From: Simon Davis
Sent: 25 January 2019 14:29
To: [REDACTED]
Cc: Daniel Vick <Daniel.Vick@arun.gov.uk>
Subject: FW: Y/92/18/DOC- Further Drainage Supporting Info

From: Laura Gibbons
Sent: 25 January 2019 11:33
To: Simon Davis <Simon.Davis@arun.gov.uk>
Subject: RE: Y/92/18/DOC- Further Drainage Supporting Info

Typical Road and Swale Section
Scale 1 : 25 at A1

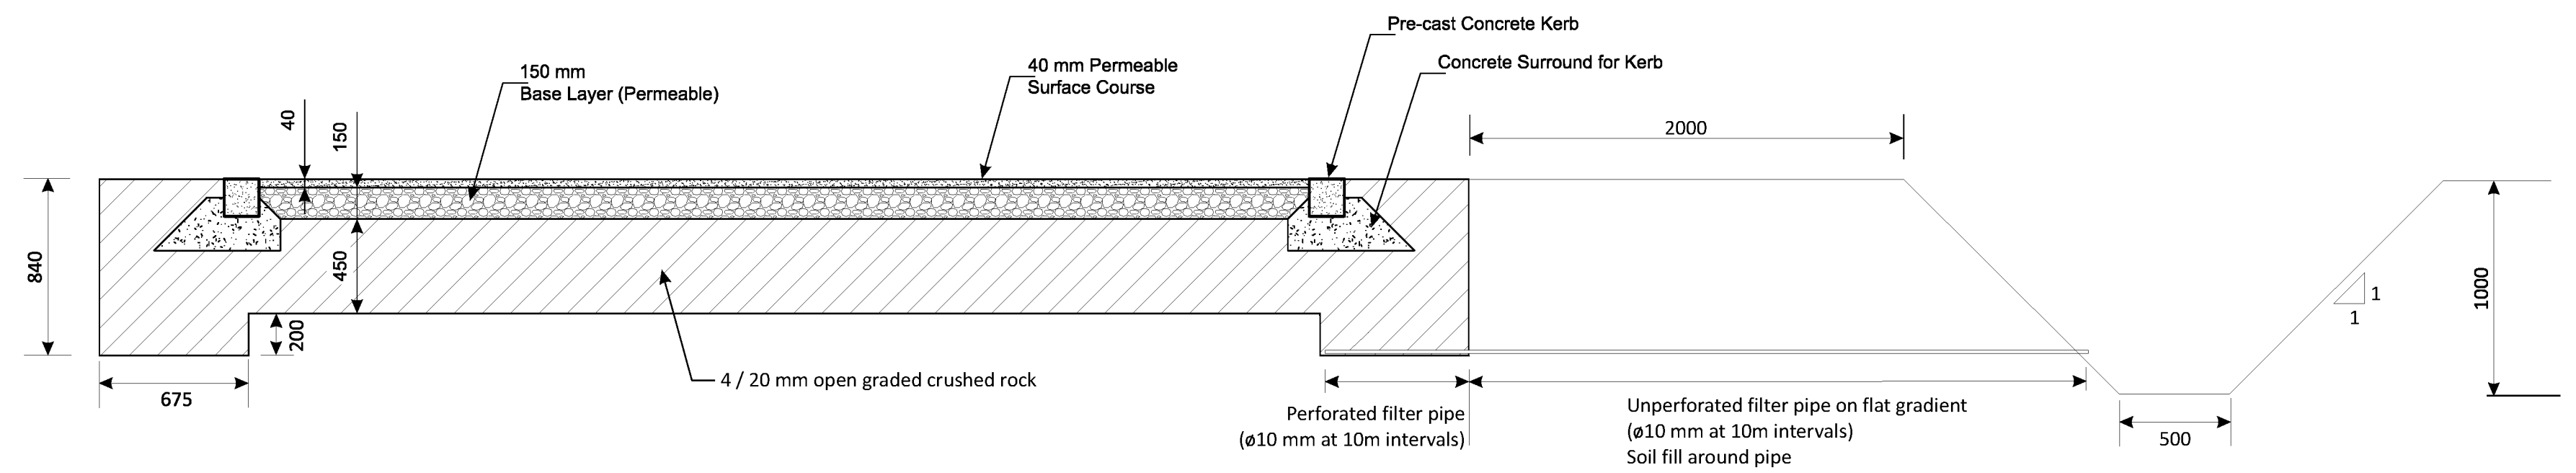
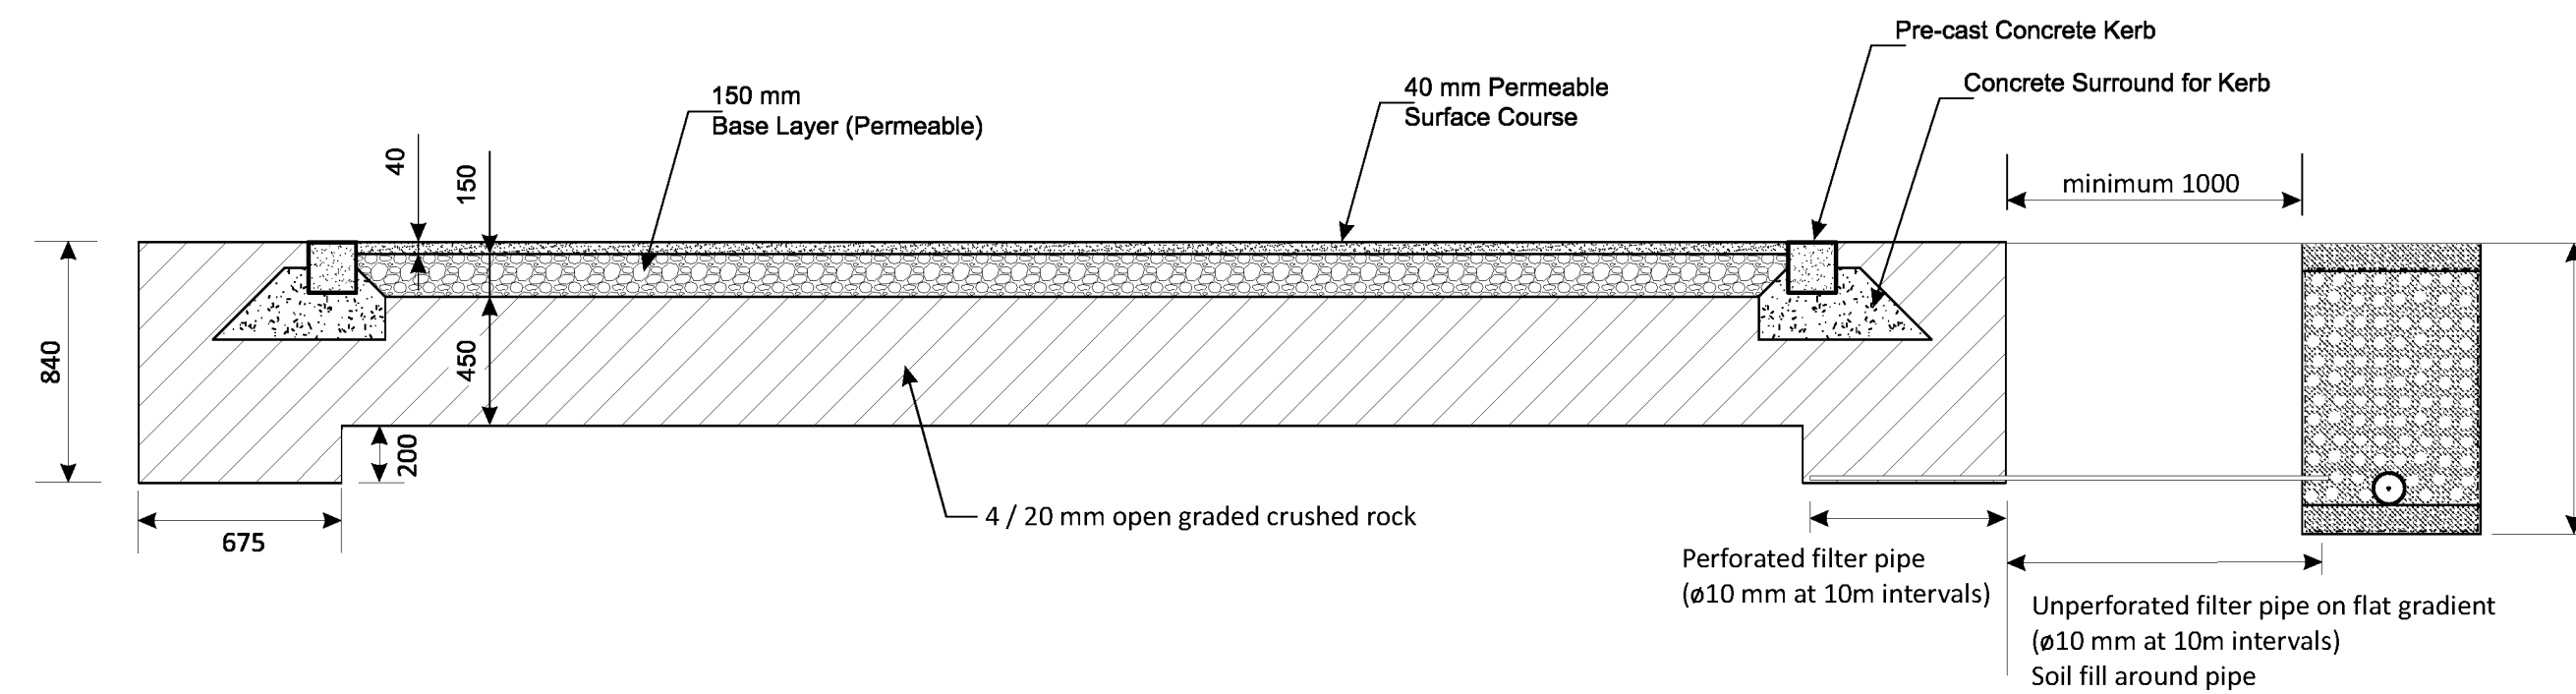
9. The permeable paving construction details need to show permeable membranes are being provided. No details of the permeable surface course have been provided, and need to be.

10. Please detail what material will be used for the 150mm permeable base layer.
11. Sufficient construction detail drawings haven't been provided.
12. Sufficient details on layout plans have not been provided.
